Ribble Valley Borough Council
Housing & Development Control

Application no: **3/2021/0514**

Address: **Chew Mill Farm Unit 1 Elker Lane Billington BB7 9HZ**

Proposal: **Proposed single storey extension to bakery and alterations to internal access.**

Site Plan 1:200

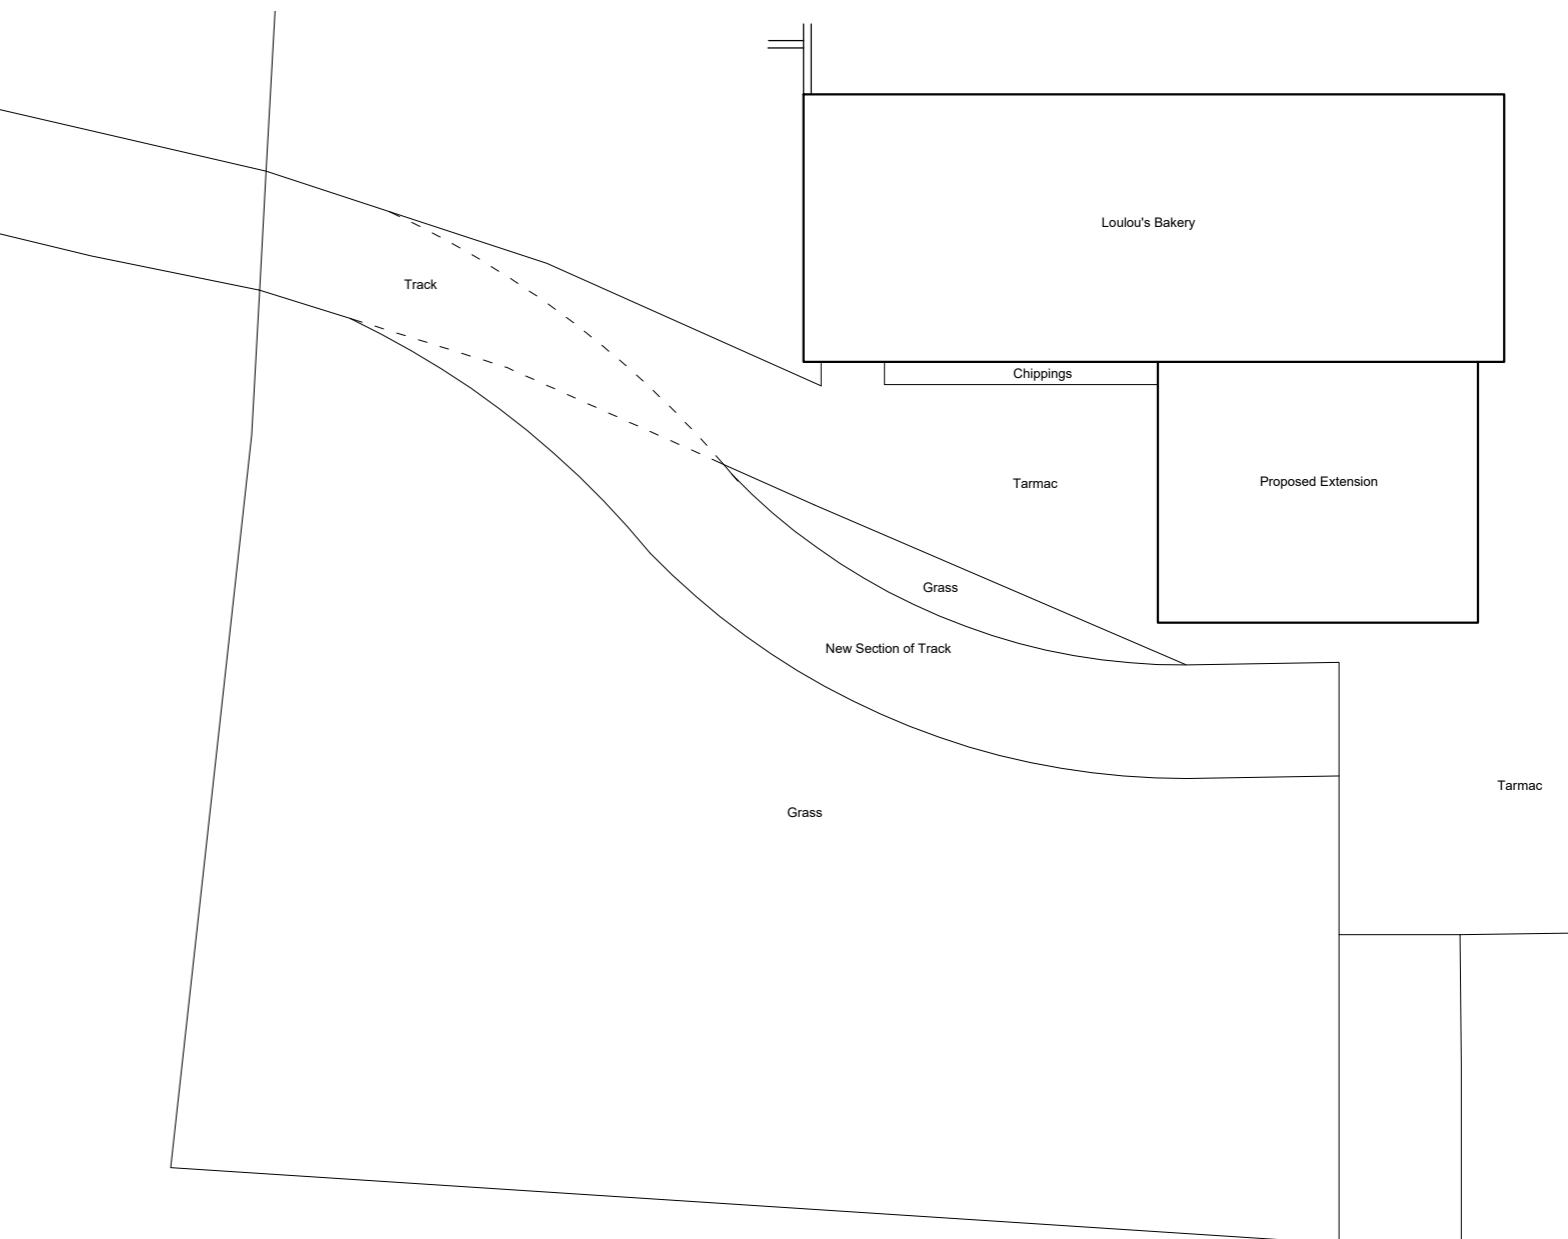
The LHA have reviewed the supporting documents and understands that the site will provide 15 car parking spaces for the bakery which will have 159 square metres of internal floorspace following the proposal.

The parking provided at the site meets the guidance set in the Joint Lancashire Structure Plan and therefore the LHA have no objections to the proposal.
